**Application by Highways England for the A1 in Northumberland: Morpeth to Ellingham**  
**The Examining Authority's written questions and requests for information (ExQ4)**  
**Issued on 24 May 2021.**

The following table sets out the Examining Authority's (ExA's) fourth round of written questions and requests for information – ExQ4. Questions are set out using an issues-based framework derived from the Initial Assessment of Principal Issues provided as **Annex C** to the Rule 6 letter of 19 November 2020. Questions have been added to the framework of issues set out there as they have arisen from representations and to address the assessment of the application against relevant policies.

Permanent Works at the River Coquet

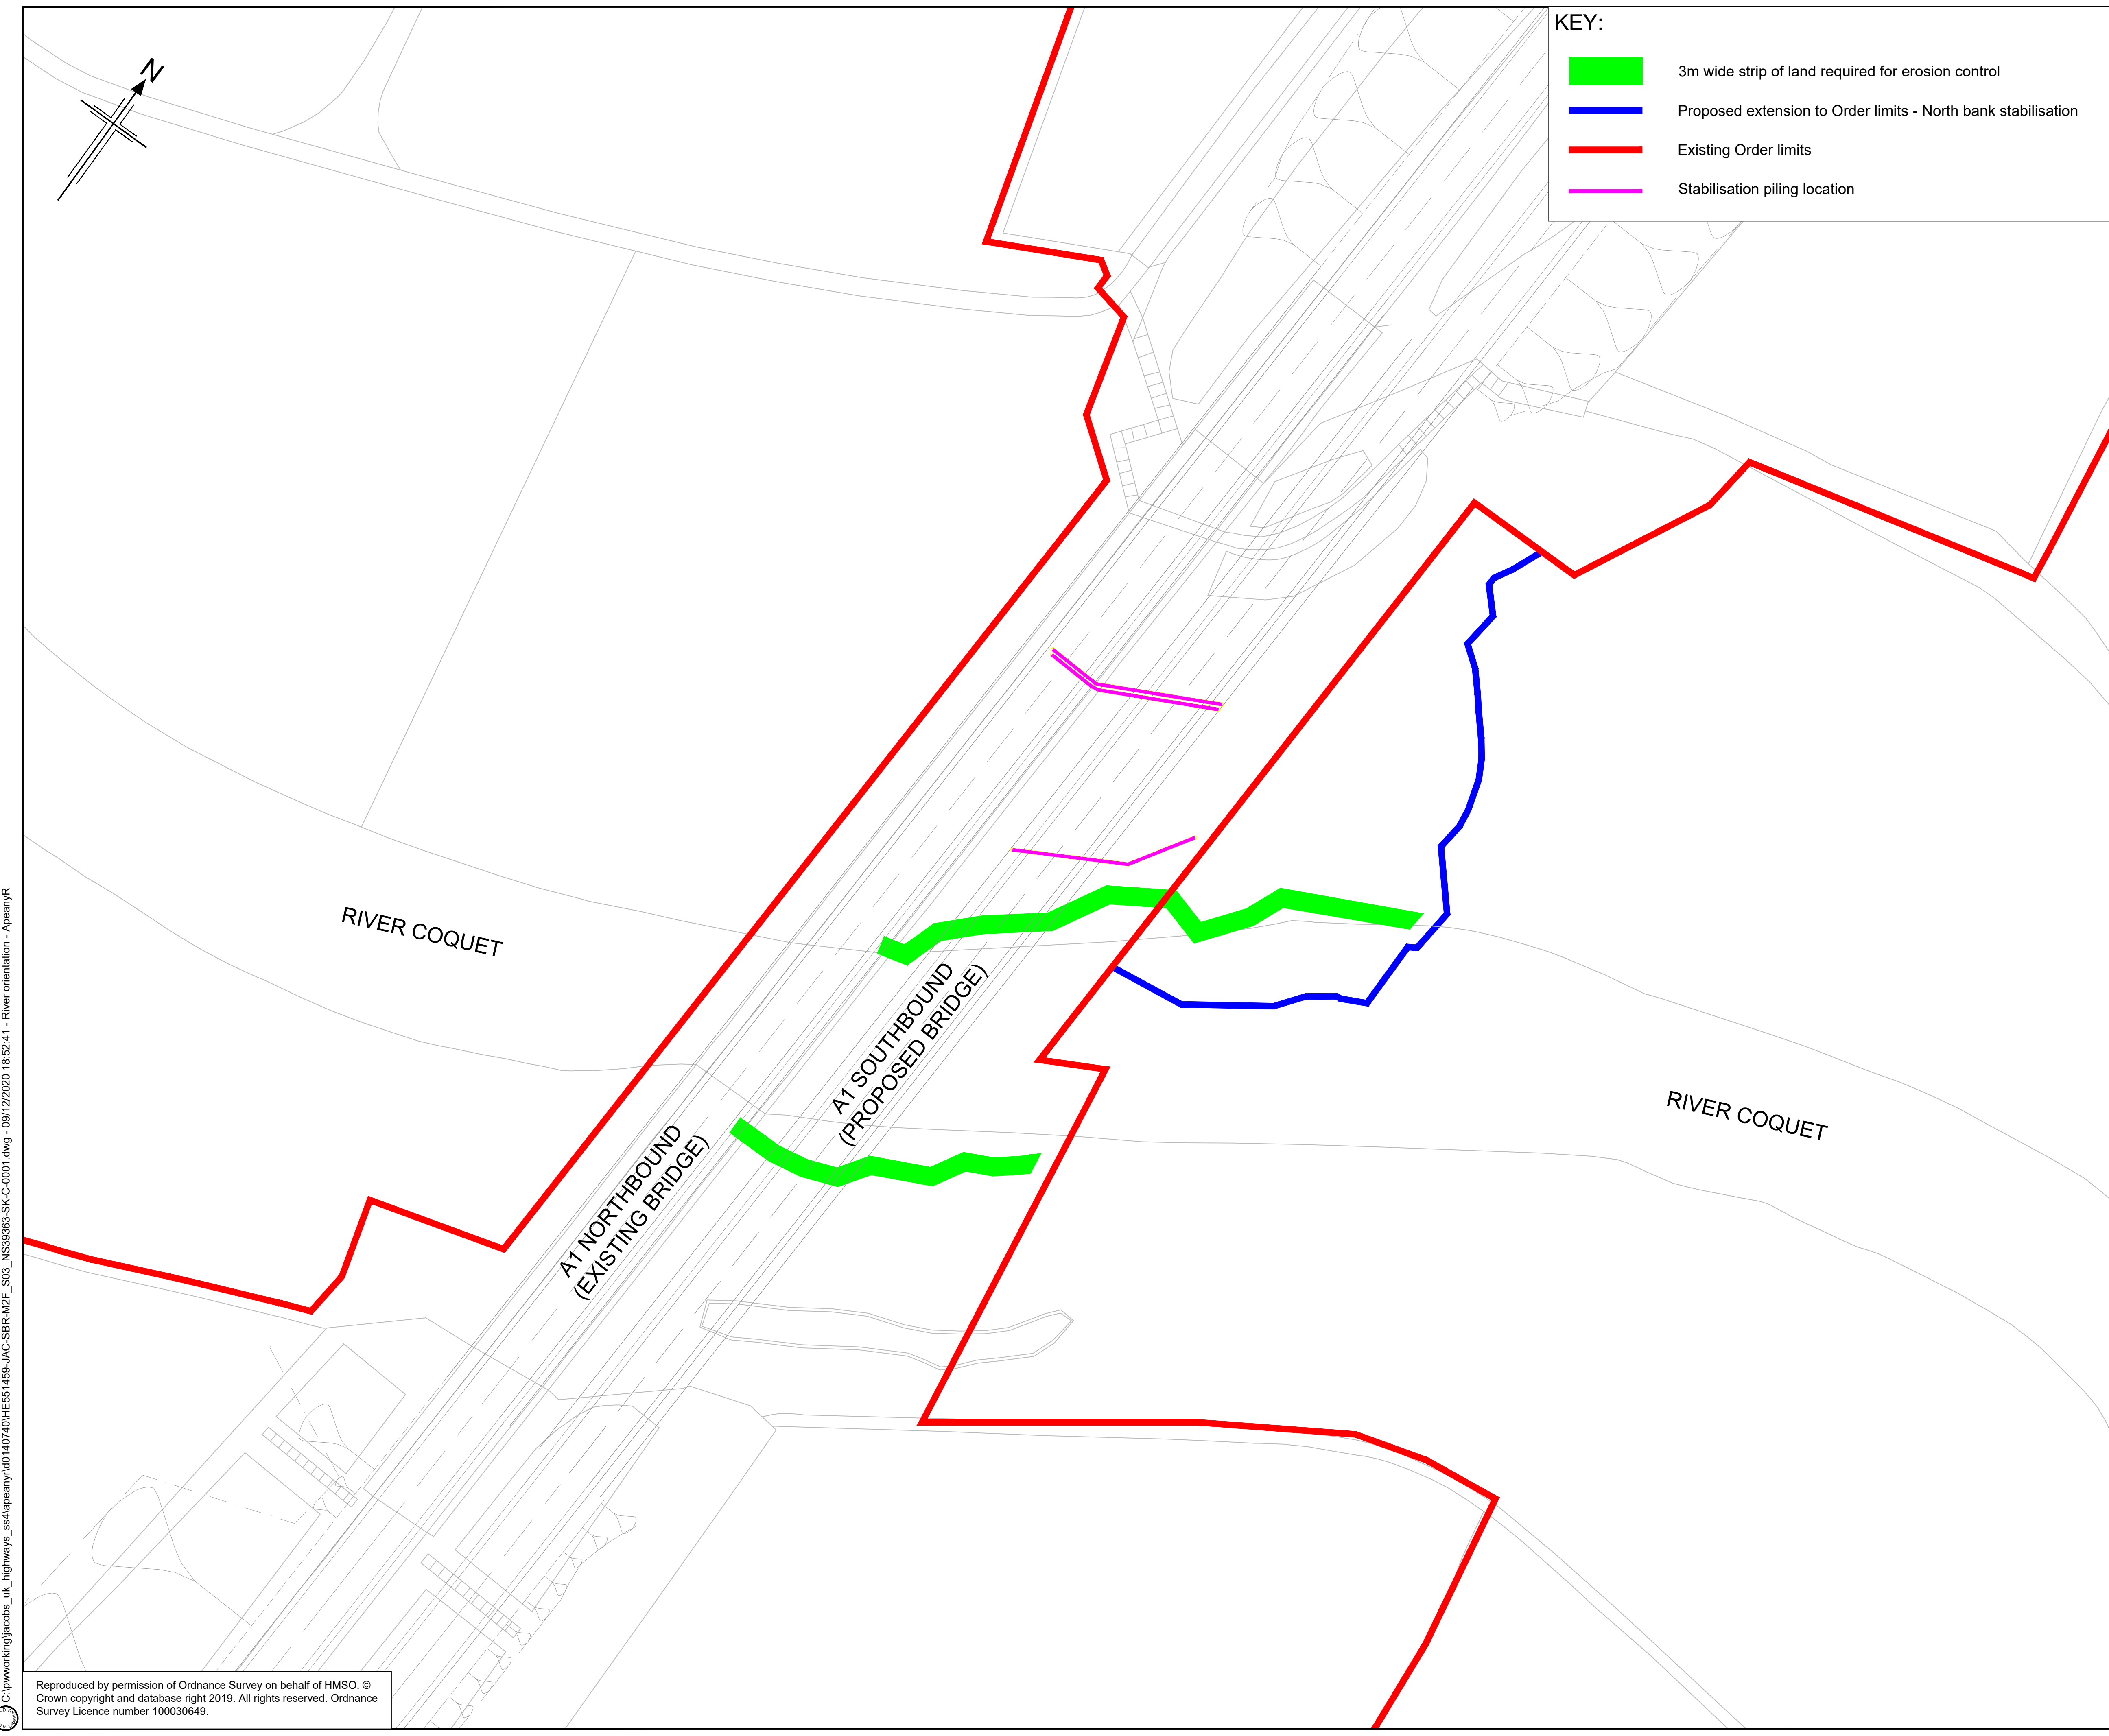
<b>ExQ4</b>	<b>Question to:</b>	<b>Question:</b>
WE.4.4	EA	<p>The EA [REP5-044] asked for confirmation of the type of lining to be utilised in Borrow Pit 4, as it is proposed to be used as a detention basin. The EA also raised concerns regarding the methodology used in order to backfill Borrow Pits 1 and 2 and also requested further information regarding the proposed long-term use of Borrow Pits 3 and 4. the Applicant, in [REP6-040], has addressed this matter.</p> <p>Can the EA confirm it is satisfied that its concerns have been addressed?</p>
WE.4.5	Applicant	<p>The EA [REP5-044] and NE [REP5a-004] have both raised concerns regarding the proposed scour protection (rock armouring) associated with the change request for Stabilisation Works and Southern Access Works. The proposed scour protection would lead to the permanent loss of bankside habitat from with the SSSI.</p> <p>How does the Applicant propose to address the adverse effects of the rock armouring, particularly in relation to the loss of the riparian zone?</p>
